Consultation Response from KC Highways Development Management
2019/91883 adj, Castlegate, Huddersfield
Advertisement Consent for erection of digital advertising screen (within a Conservation Area)
Date Responded: 03/01/20 Responding Officer: J Turner Responding Ref: K5-8SW/8

This application seeks advertisement consent for the erection of a digital advertising screen (within a conservation area) adjacent to Castlegate, Huddersfield.

Proposed site layout plan

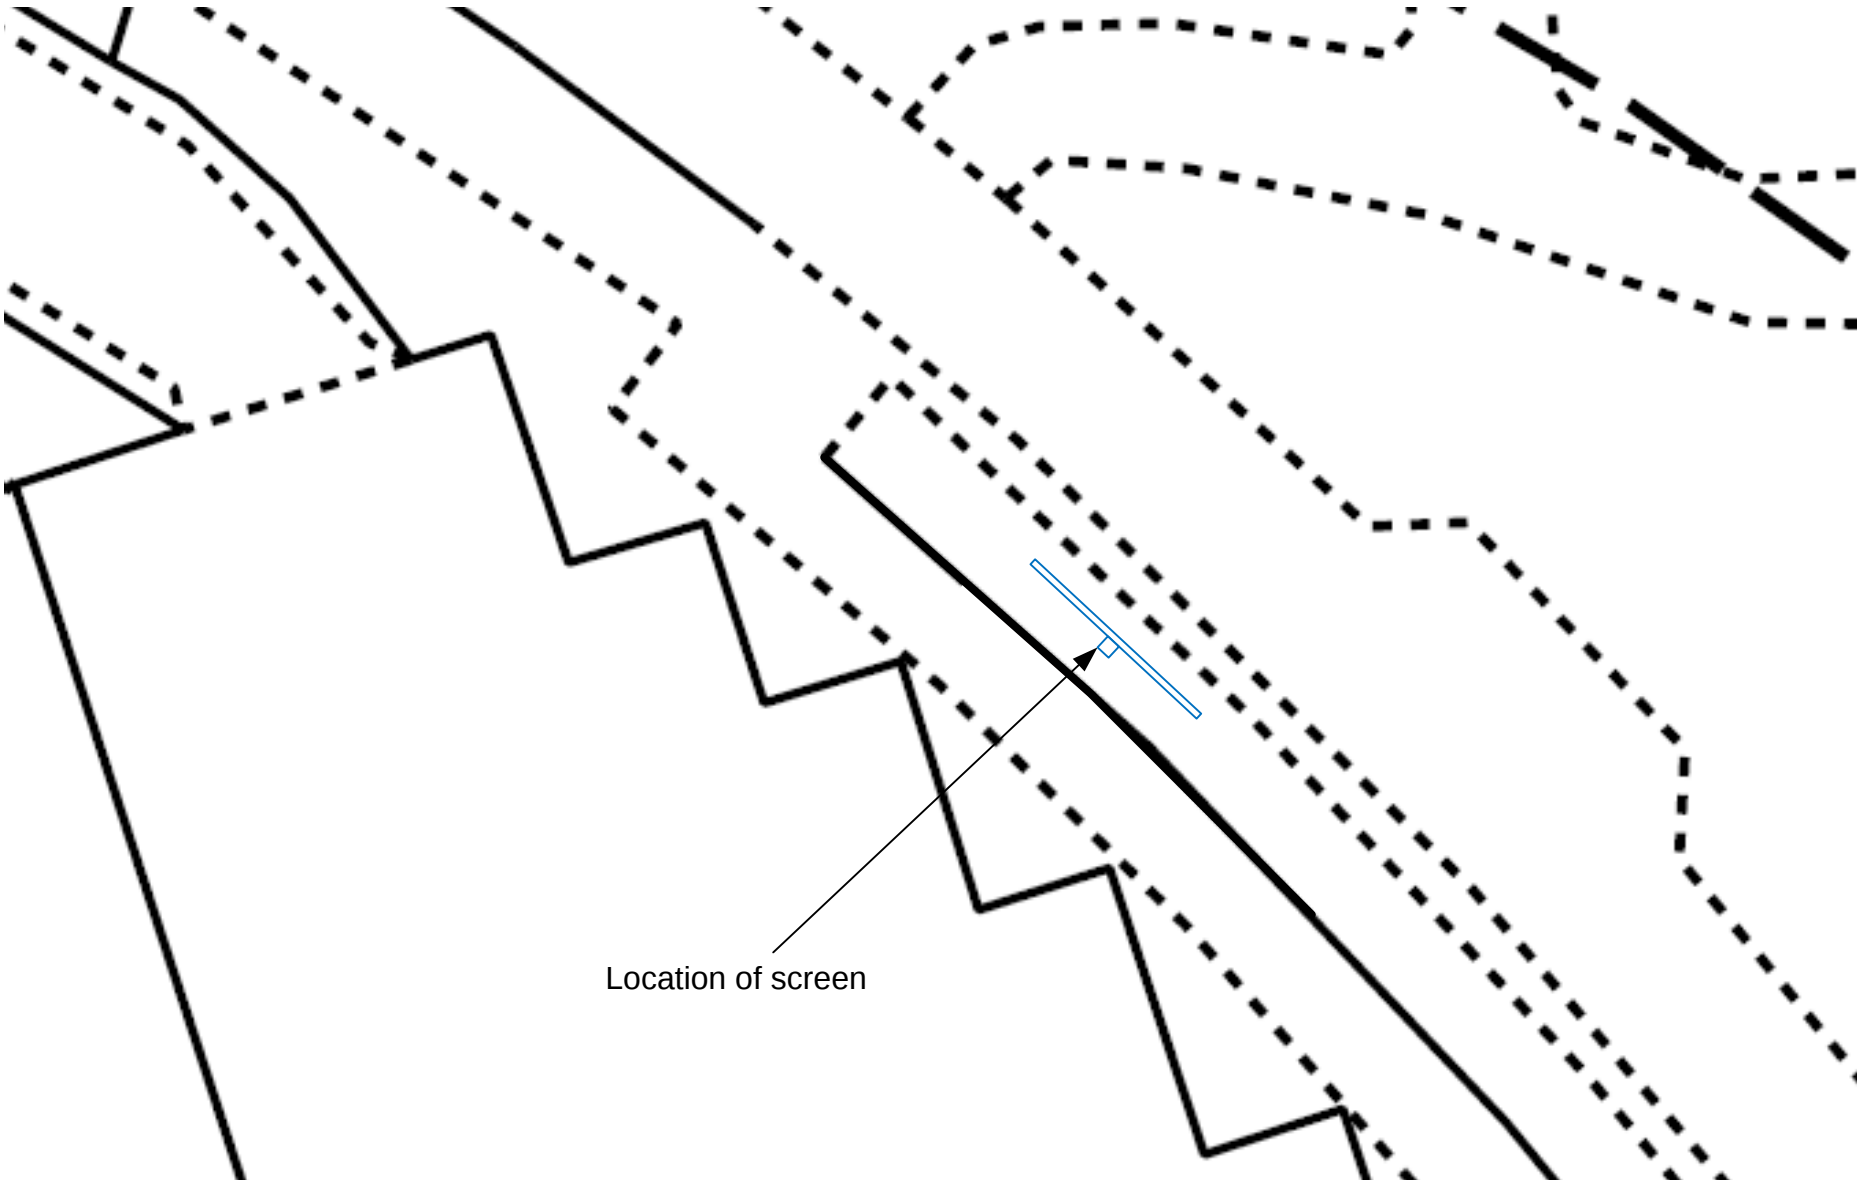
The proposed location on Castlegate is on a major five arm signalised junction on the main town centre ring road, with an abundance of pedestrian crossings and traffic signs in the vicinity. The proposed digital sign would be close to the signals and signs, and would cause the driver to look a significant distance from the signals and signs.

It should be noted that there have been six injury accidents reported in the last five years at this junction, including a serious injury accident in June 2018 directly in front of where the sign would be placed.

As suitability concerns have been raised by those whose remit it is to improve and maintain highway

safety, Highways DM can only uphold these concerns and raise objection to the scheme.
